Ribble Valley Borough Council
Development Control

Your ref 3/2020/0093
Our ref
Date 6th March 2020

Application no: 3/2020/0093
Address: Paddock Gate , Wiswell Lane Whalley
Proposal: Erection of single dwellings

Drawing Title
PROPOSED SITE PLAN
AND STREET SCENE

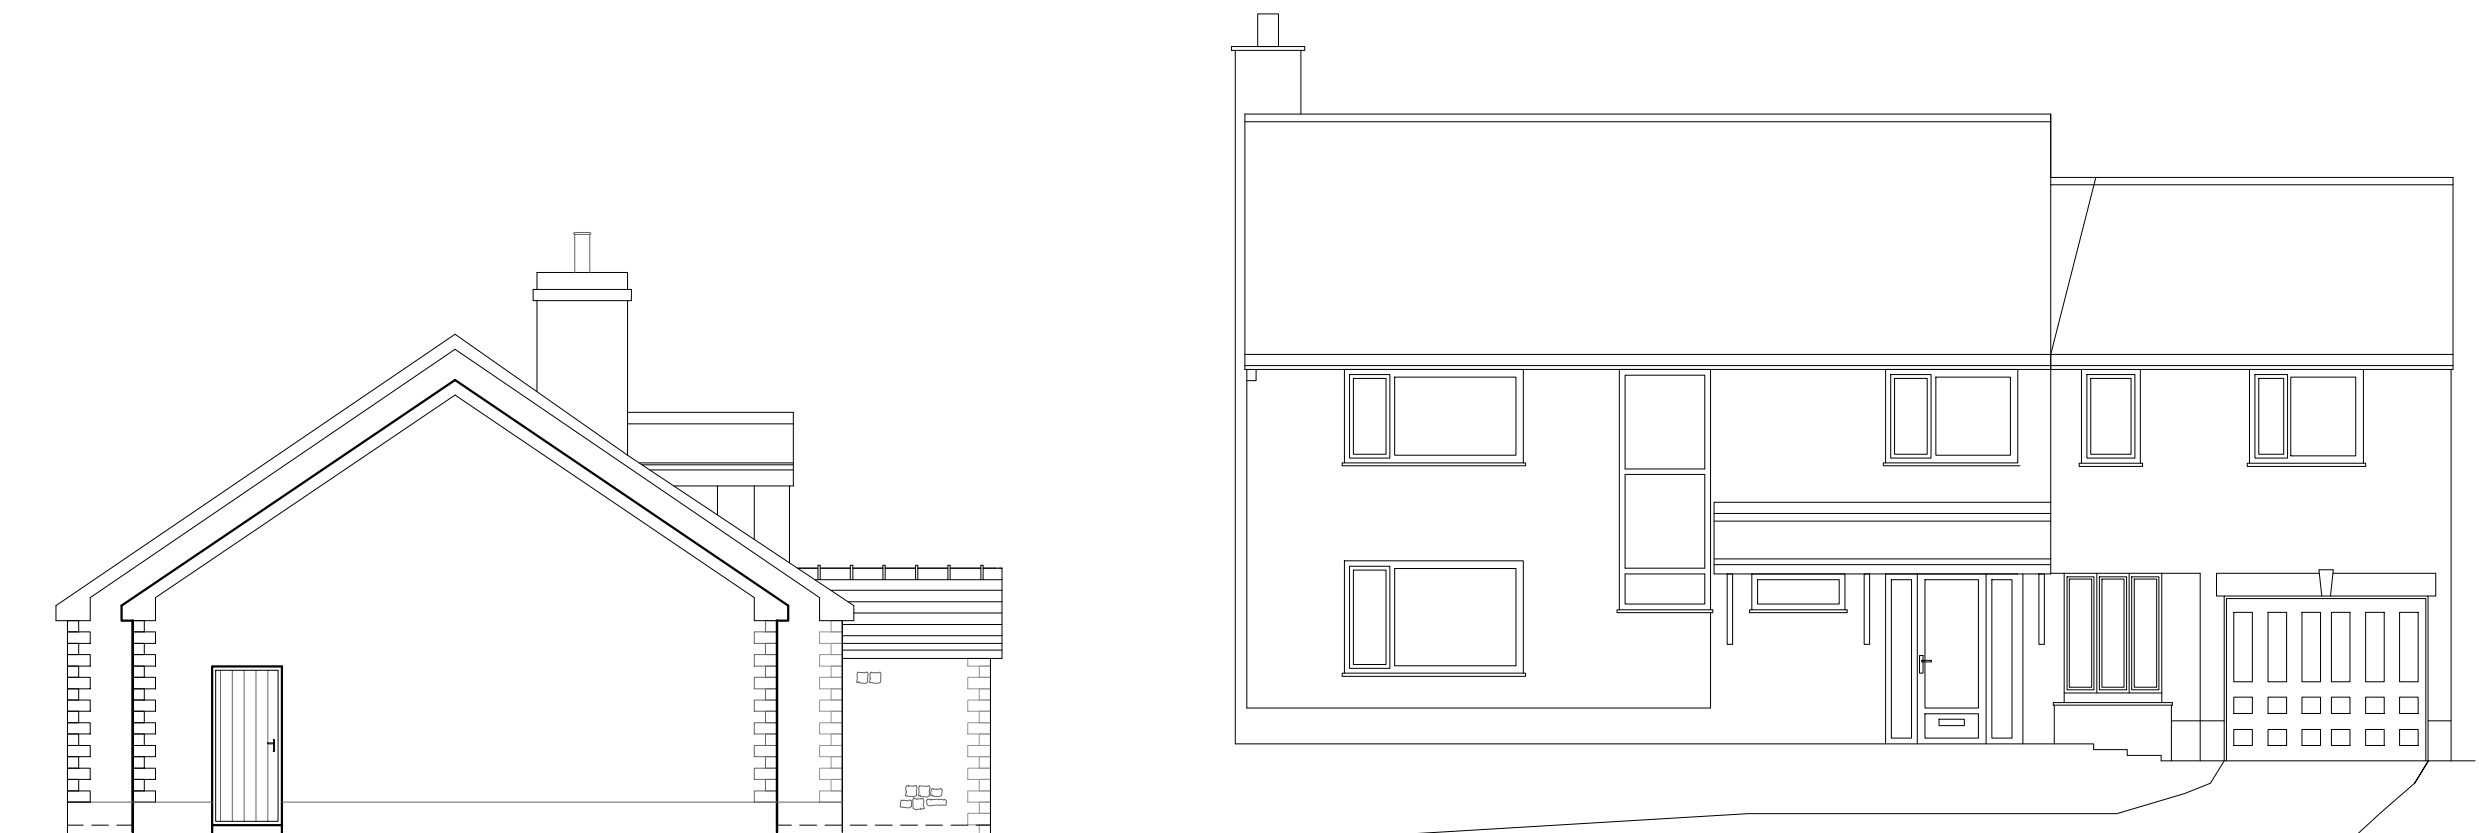
The proposal is to erect a single dwelling in the grounds of 14 Wiswell La. The proposal has been submitted previously under application 3/2019/1025 but was subsequently withdrawn. However the highway authority's response to the previous application, whilst positive, raised concerns regarding the width and suitability of the access into the site and the achievable visibility splays.

I have been unable to locate any plans showing the widening of the access within the submitted documents.

Before I can provide my formal comments I would need to see a plan showing the proposed widening scheme and also the available sightlines
